**STATEMENT OF ENVIRONMENTAL EFFECTS: SECTION 75W APPLICATION, MODIFICATIONS
TO MAJOR PROJECT MP NO.10_0158 (BUILDINGS 7 & 8) – 61 MOBBS LANE, EPPING**

Pursuant to Section 75W (1) (a) of the Environmental Planning and Assessment Act 1979, a 'modification of approval' is sought to vary Condition No. A2 pertaining to Major Project MP No. 10_01581 (Buildings 7 & 8) as approved on the 12 July 2011. The modification is to amend architectural plans to accommodate minor design changes.

Title Building 8 Level 5 & Roof Plan

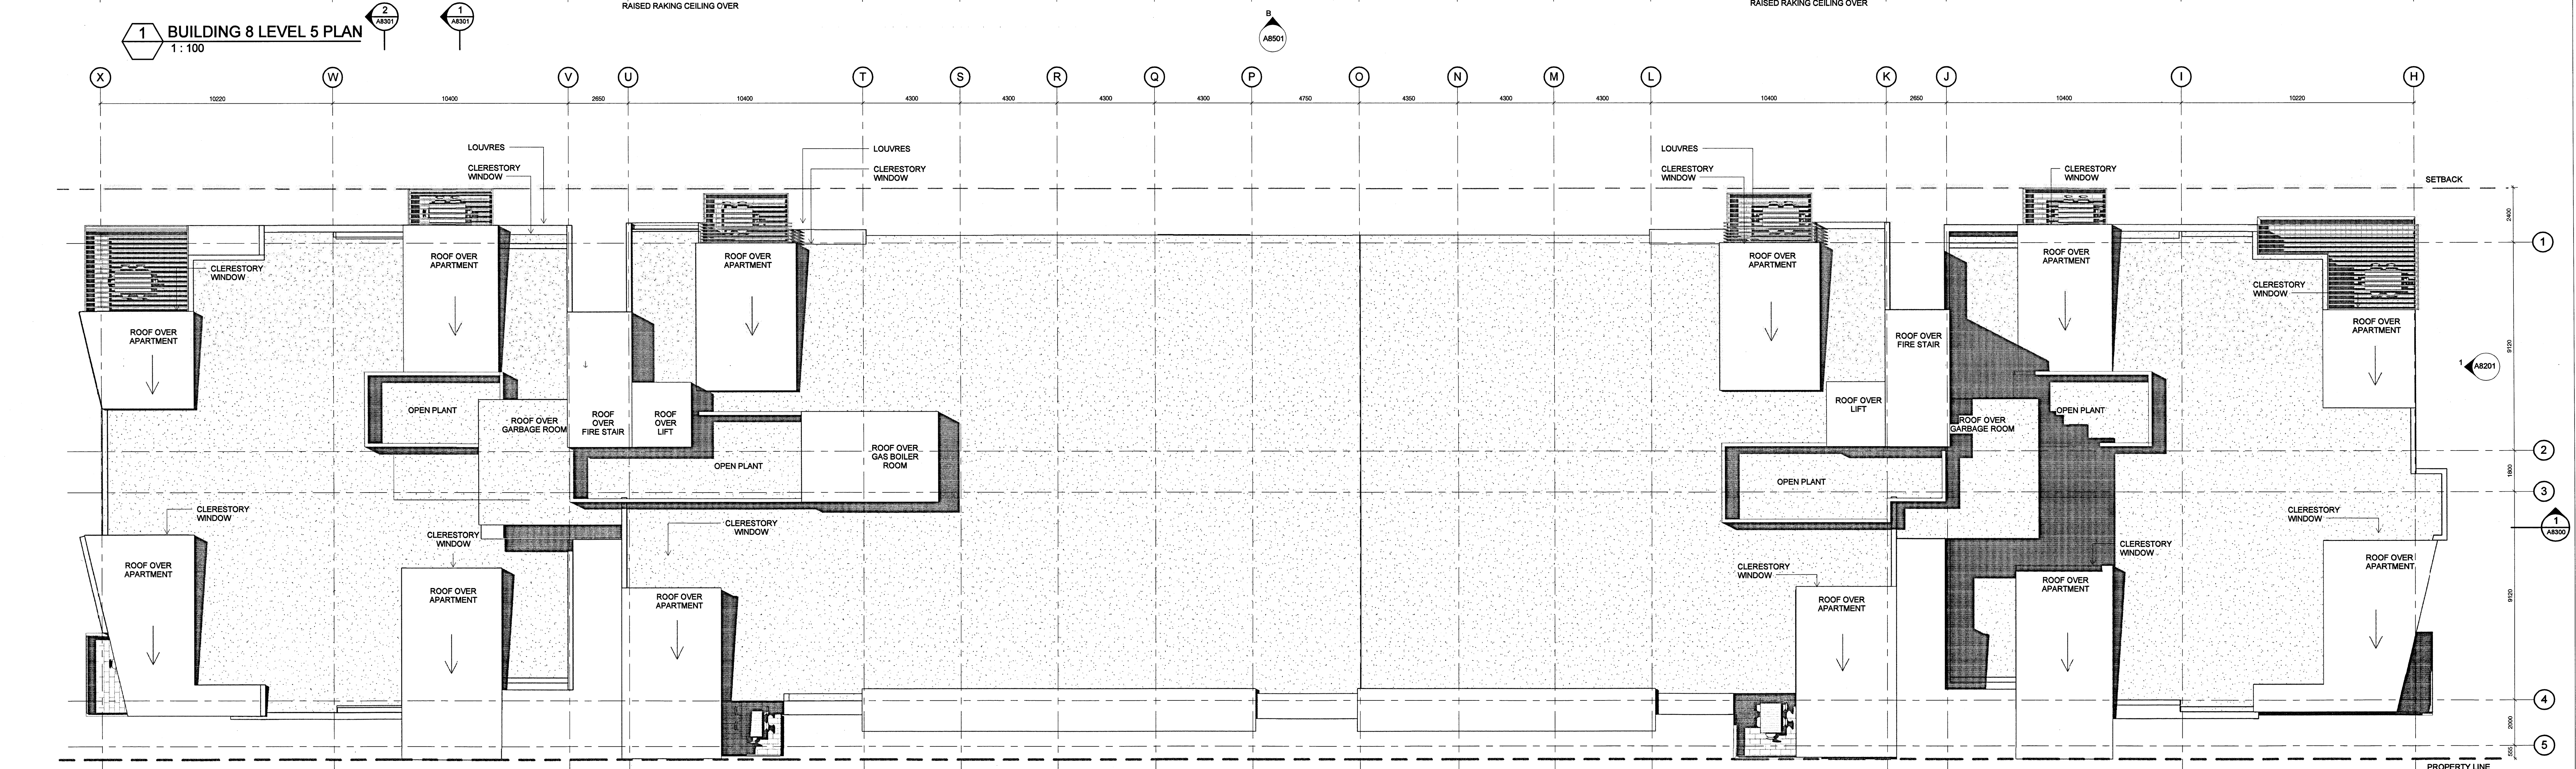
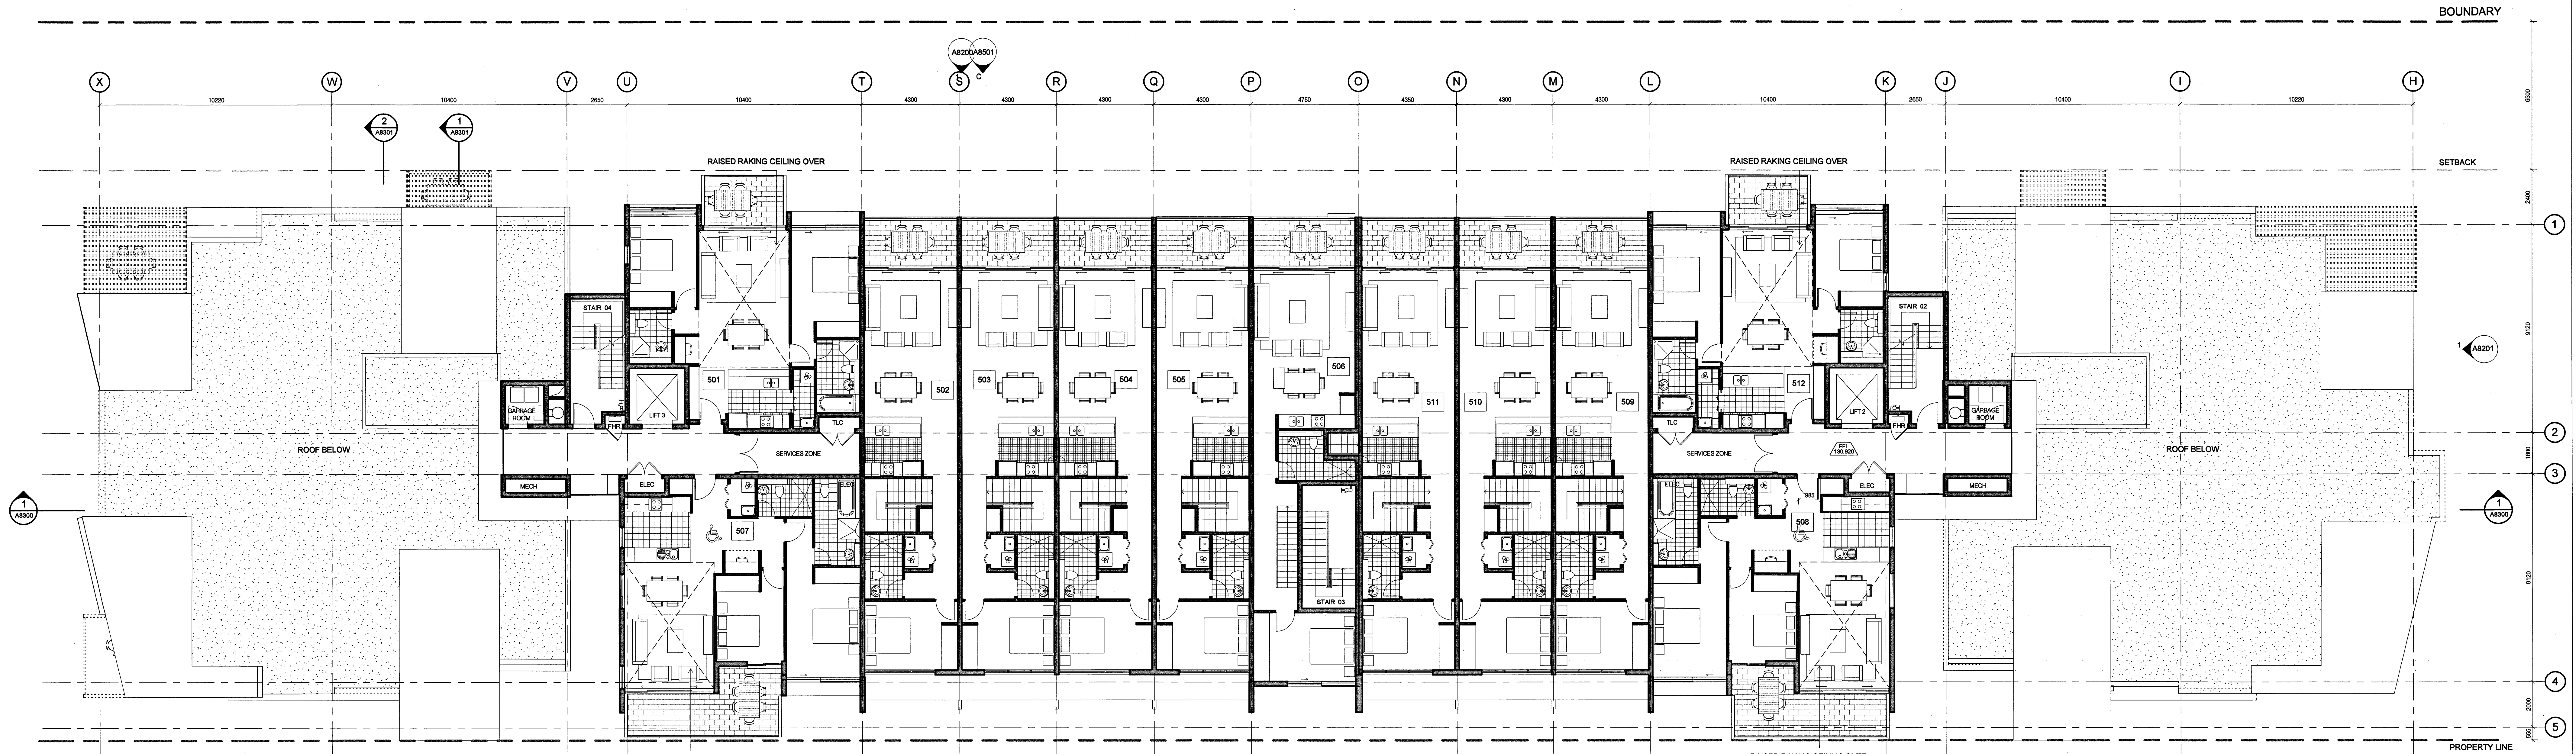
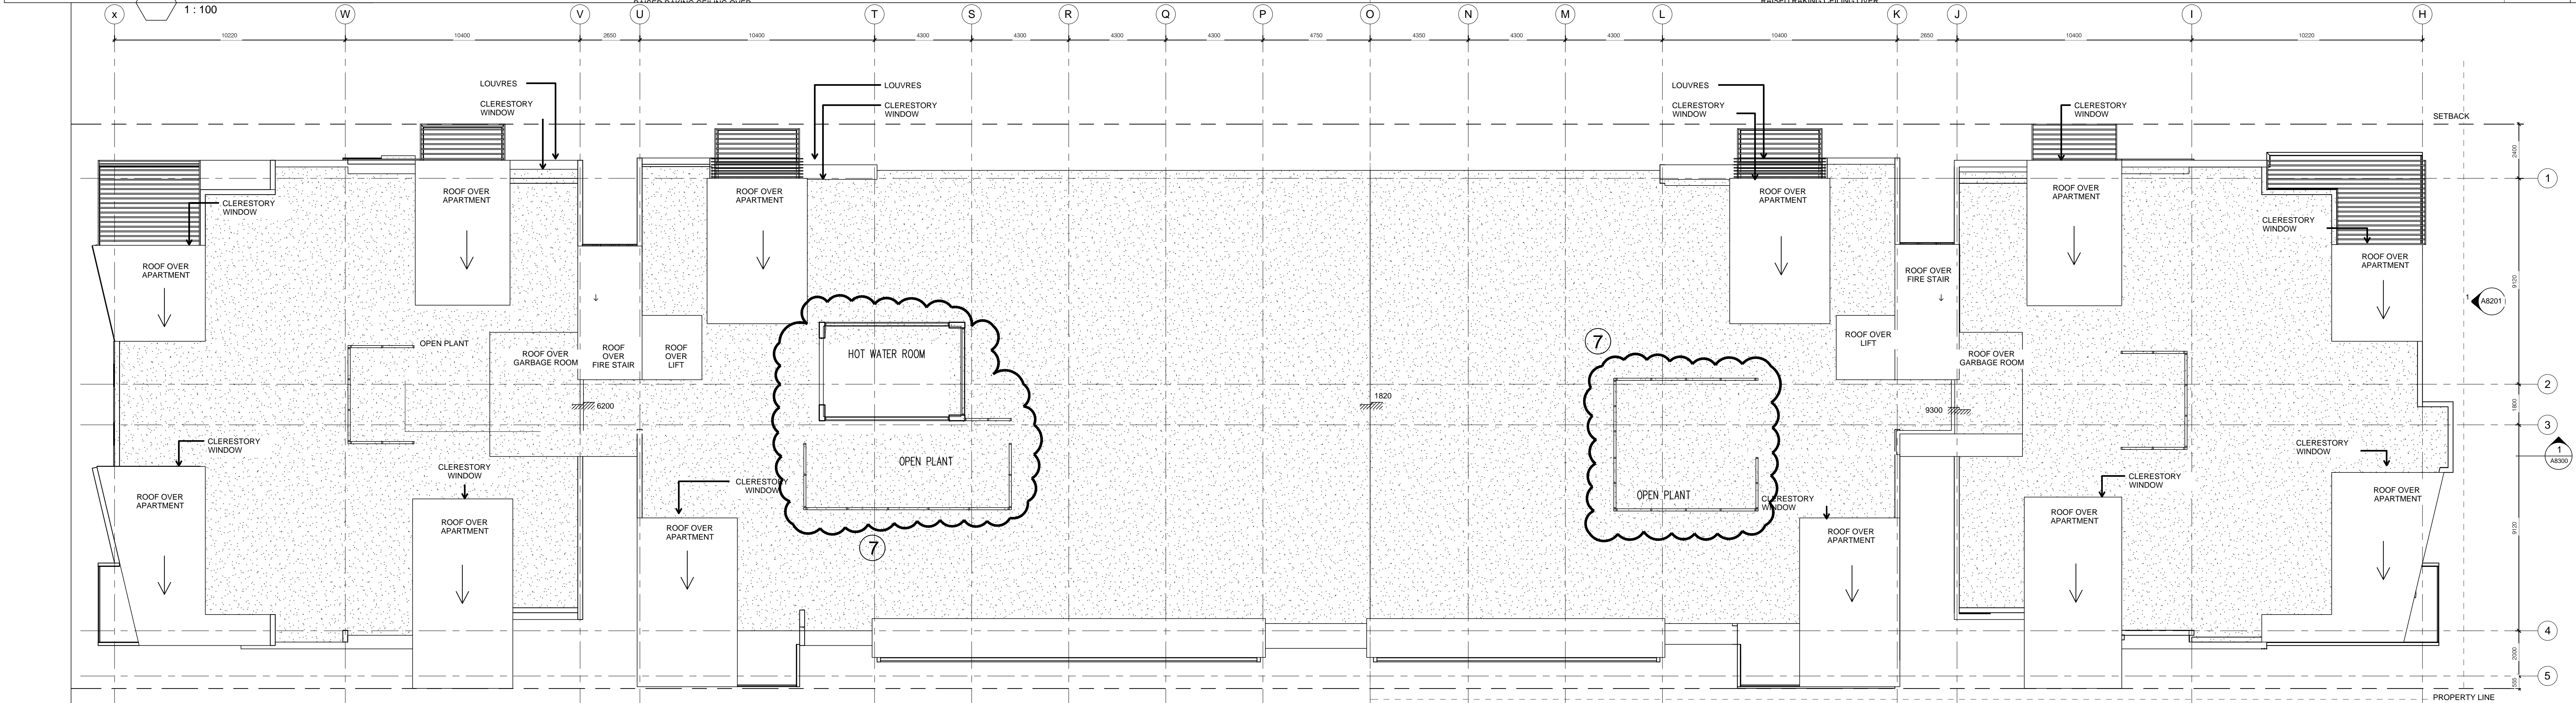
Building 7 Existing Approval	Building 7 Proposed Modification (Numbering as per the legend on the submitted plans)
Ground Floor Plan, A7101	Ground Floor Plan, A7101, Rev A 2. Wall removed 3. Modification of unit 4. Courtyard standardised 5. Courtyard extended 11. Carpark egress removed
B7 Elevations, A7200	B7 Elevations, A7200, Rev A 8. Reconfiguration of courtyard fence
Building 8 Existing Approval	Building 8 Proposed Modification
Ground Floor Plan, A8103	Ground Floor Plan A8103, Rev A 1. NIB removed 2. Wall removed 3. Modification to Unit 4. Courtyards standardised 5. Extension of courtyard
Level 1 & 2 Plan, A8104	Level 1 & 2 Plan, A8104, Rev A 3. Modification to unit 6. Window removed
Level 3 & 4 Plan, A8105	Level 3 & 4 Plan, A8105 Rev A 6. Window Removed 7. Reconfiguration of louvre screens
Level 5 & 6 Roof Plan, A8106	Level 5 & 6 Roof Plan, A8106 Rev A 6. Window Removed 7. Reconfiguration of louvre screens
